An  
Bord  
Pleanála

## Inspector's Report

### ABP-317874-23

Extraction of sand and gravel from quarry. An Environmental Impact Assessment Report (EIAR) and a Natura Impact Statement (NIS) have been submitted.

DRAWING NO:
AI-01

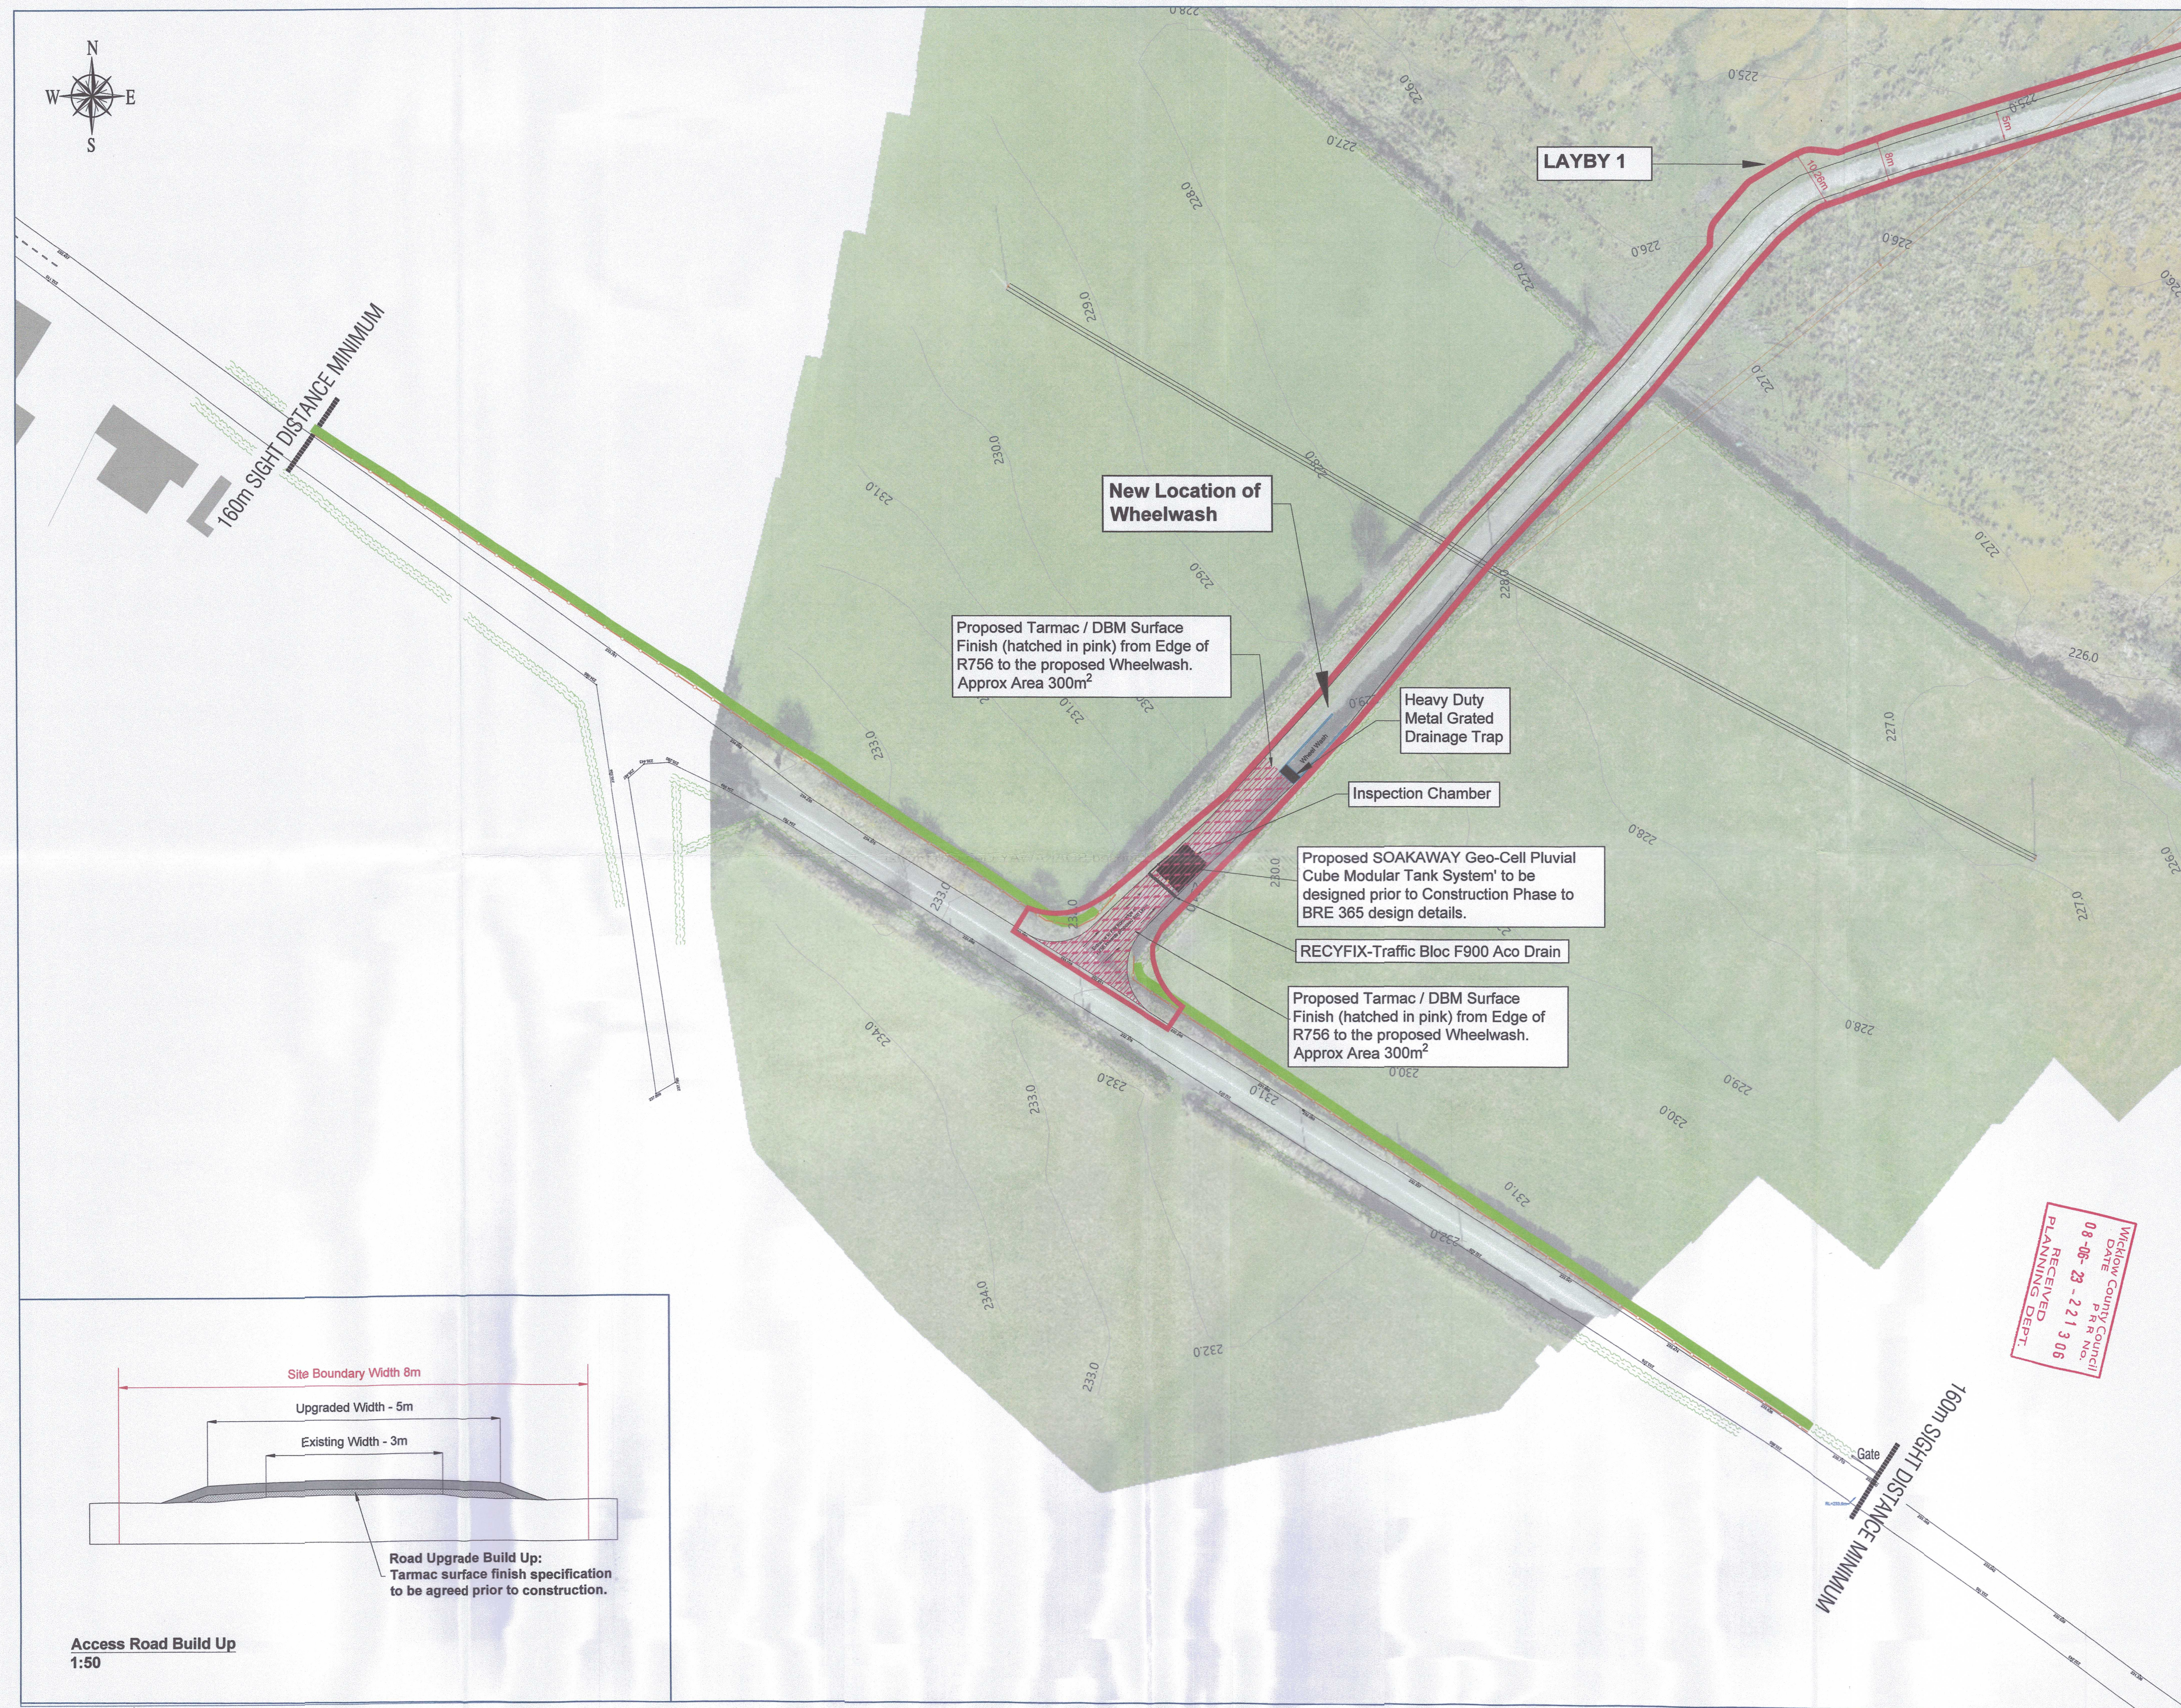
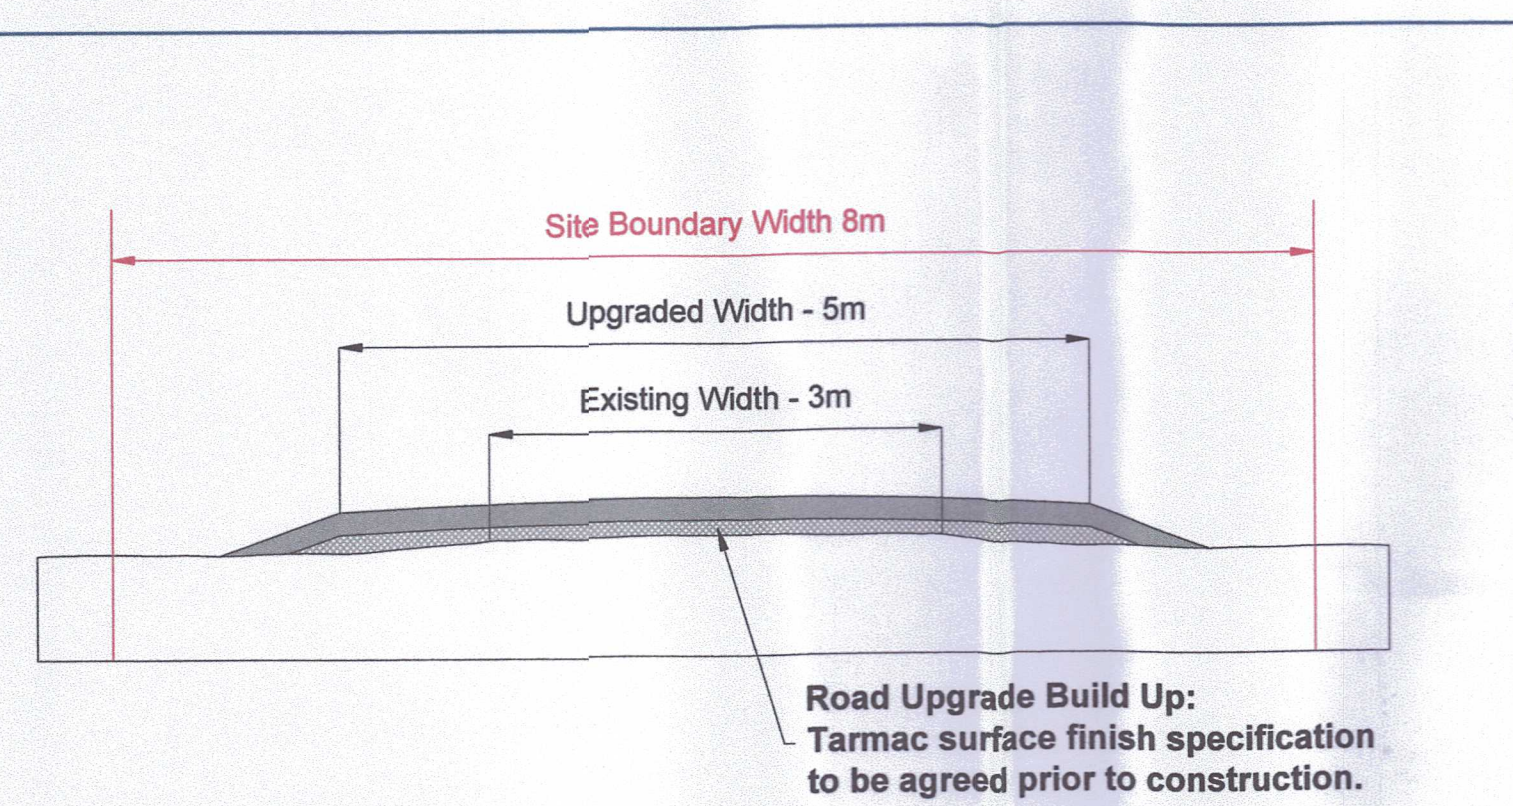
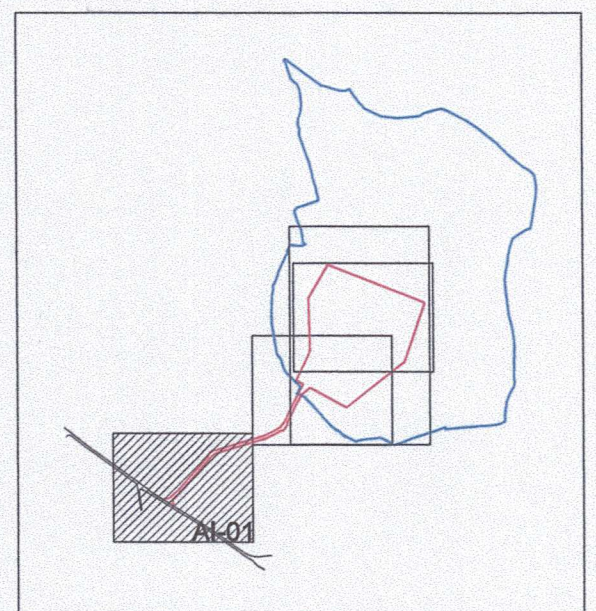
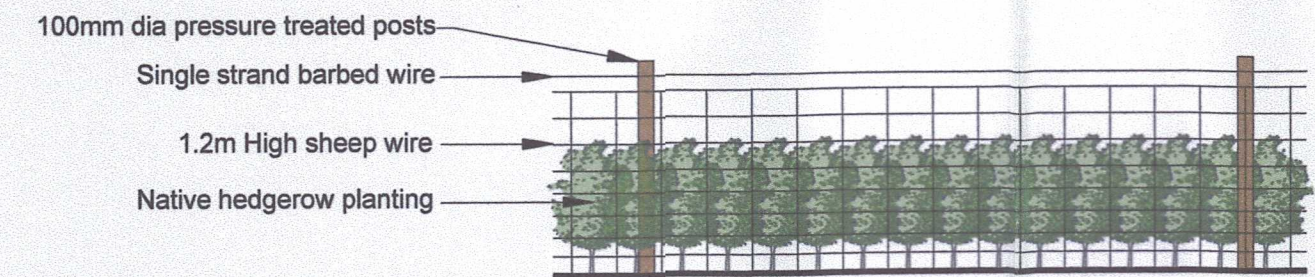
- The proposed development would endanger public safety by reason of serious traffic hazard because the proposal to provide sightlines by maintaining the height of existing boundary hedgerows is considered wholly inadequate.

- Updated plans to remove the hedgerows/trees on either side of the proposed entrance to facilitate adequate sightlines. (letter of consent from landowner attached)

- Update sightlines and details how they are to be maintained during the lifetime of the operations.
- Confirmation that the field access to the south-east of the entrance is to be permanently closed.
